***Planning Department
Transportation Development Services***

November 4, 2015

**Re: ABQ Uptown Assisted Living
7611 Indian School Rd., NE
Traffic Circulation Layout**
Engineer's/Architect's Stamp dated 10-28-15 (H19-D082)

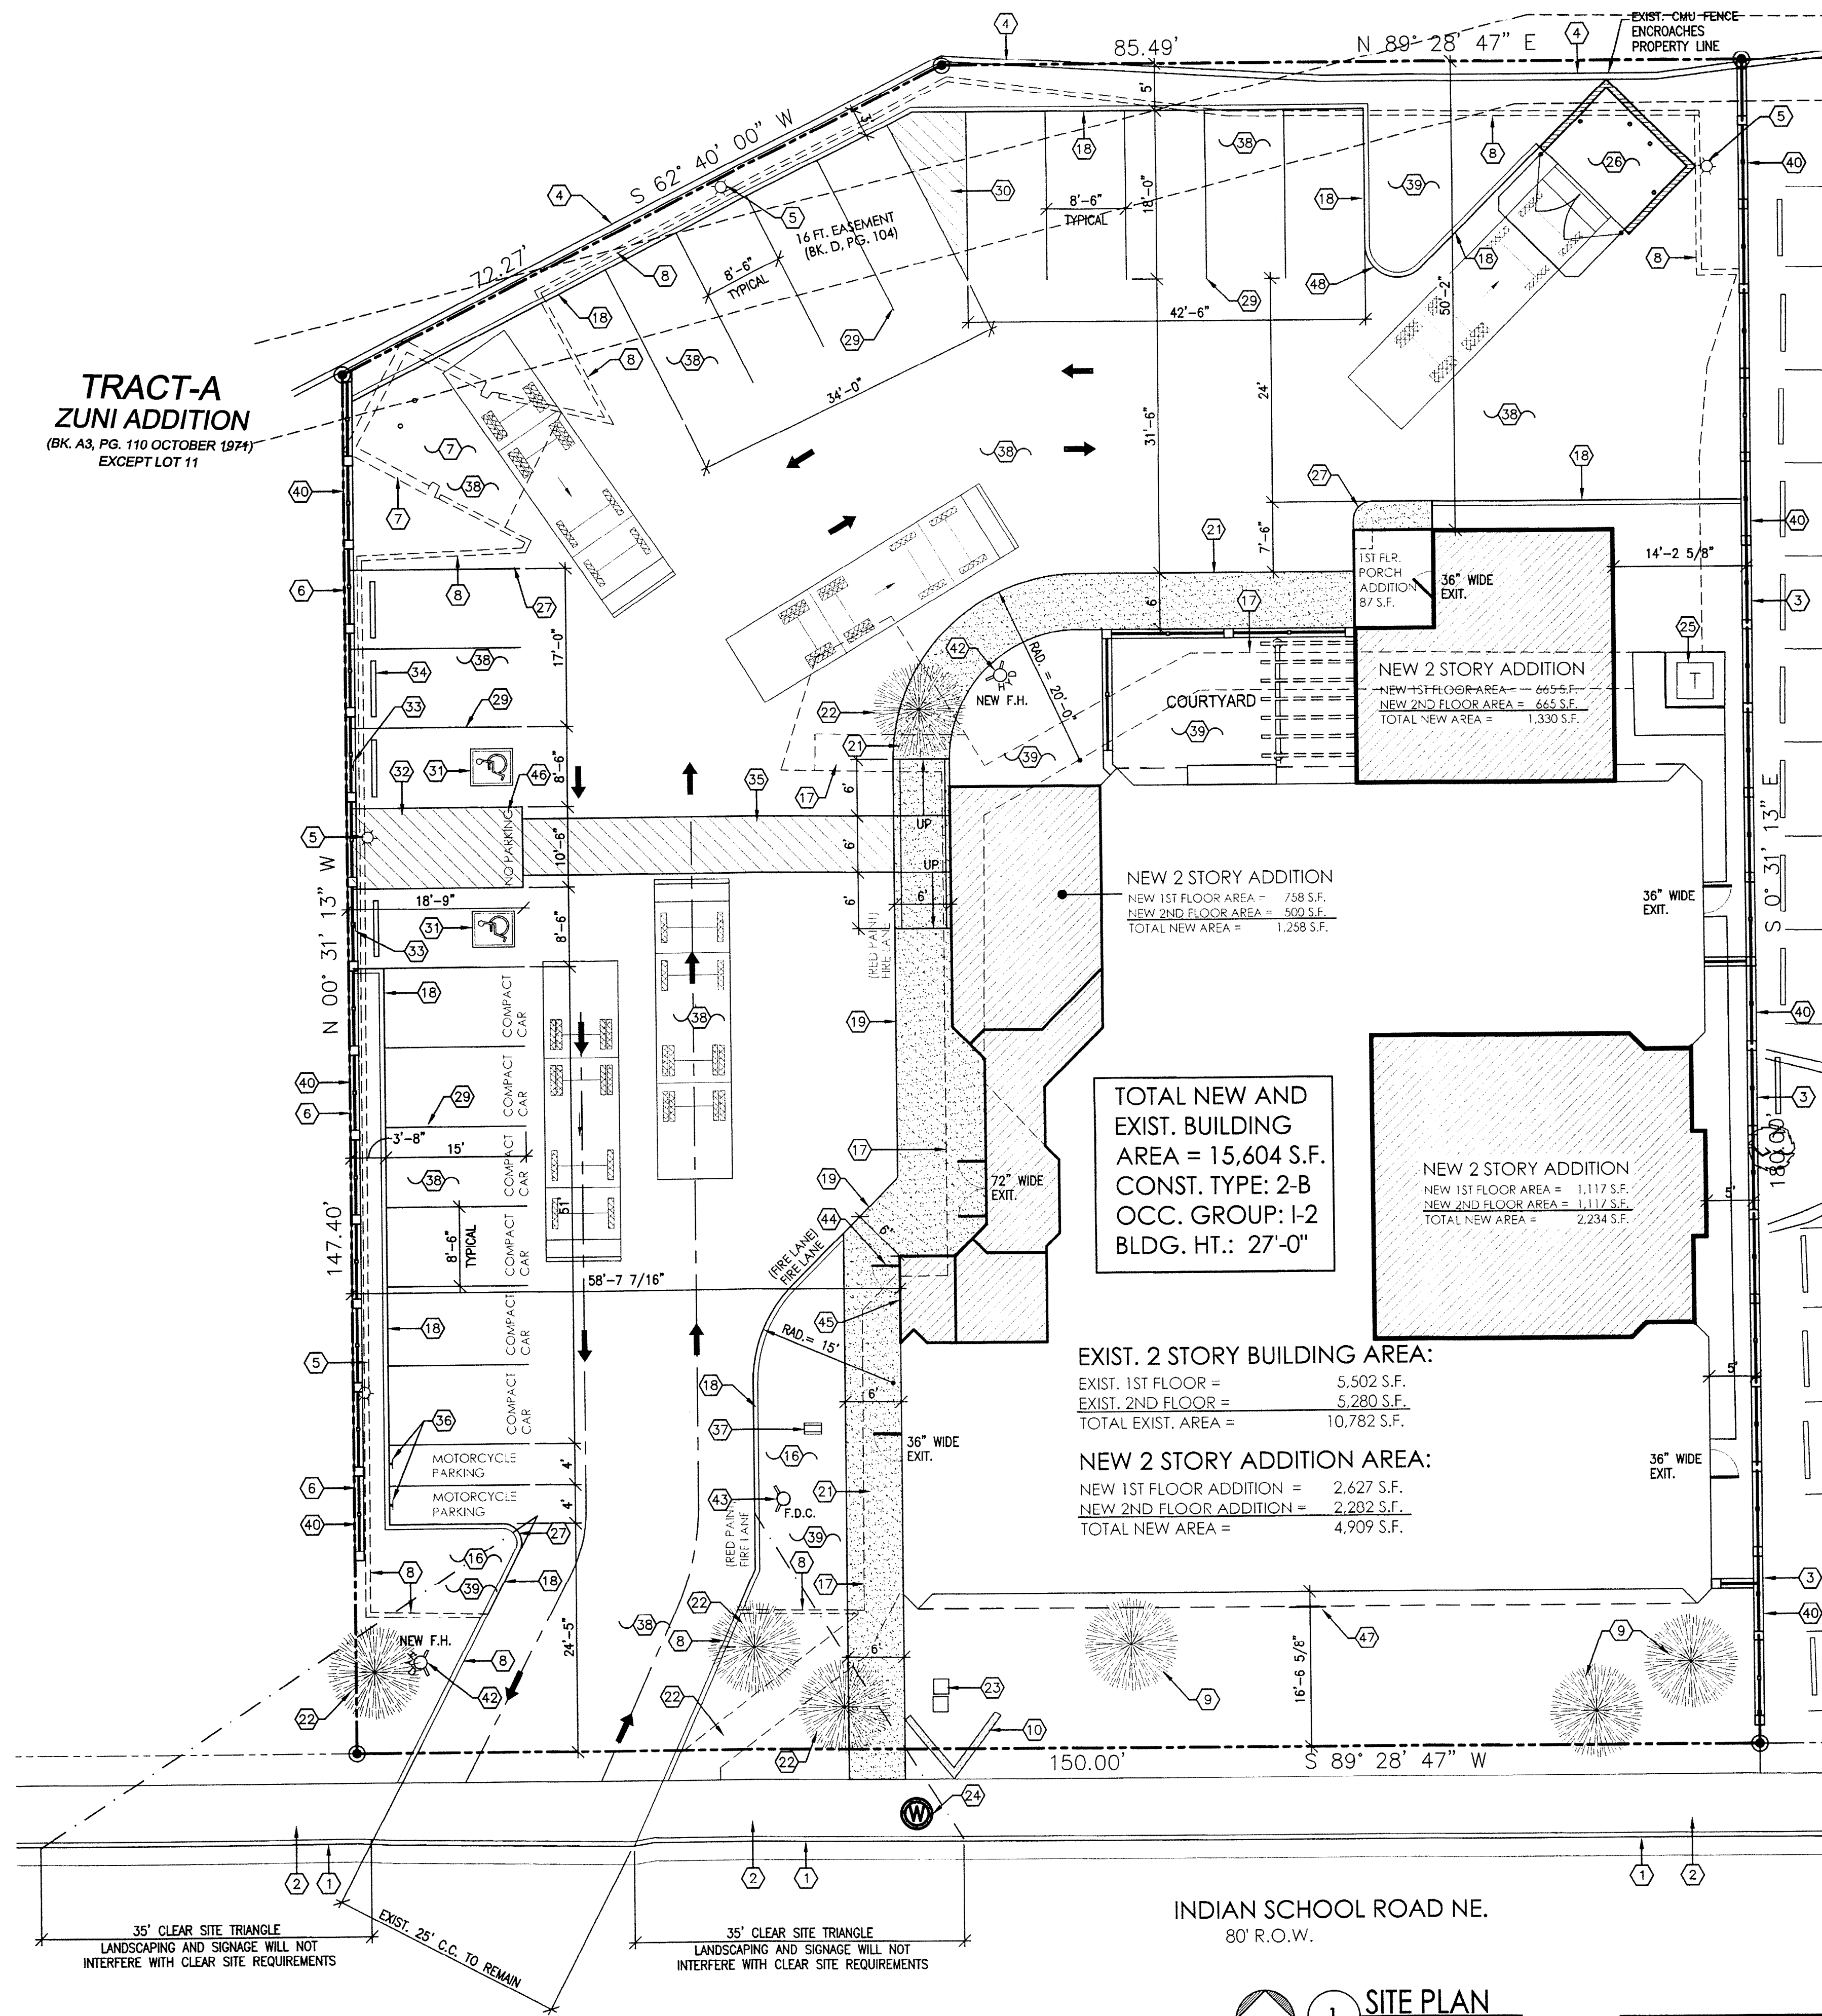
1. Per the DPM, a 6 ft. wide ADA accessible pedestrian pathway is required from the public sidewalk to the building entrances. Please clearly show this pathway and provide details. In review of drawing C-1.0, the proposed pedestrian pathway is only 5 ft. wide.
2. Per the DPM, a 6 ft. wide ADA accessible pedestrian pathway is required from the HC parking stall access aisles to the building entrances. In review of drawing C-1.0, the proposed pedestrian pathway is only 4 ft. wide.
3. Service vehicle and/or refuse vehicle maneuvering must be contained on-site; provide a copy of refuse approval.
4. Please provide a sight distance exhibit (see the *Development Process Manual, Chapter 23, Section 3, Part D.5 Intersection Sight Distance*). Please provide this detail for both entrance/exits on Indian School Rd.(Tract A and Lot 10-A)

5. Please add the following note to the clear sight triangle: "Landscaping and signage will not interfere with clear sight requirements. Therefore, signs, walls, trees, and shrubbery between 3 and 8 feet tall (as measured from the gutter pan) will not be acceptable in this area."
6. Please include a copy of your shared access and parking agreement with the adjacent property owner.
7. Please include two copies of the traffic circulation layout at the next submittal.
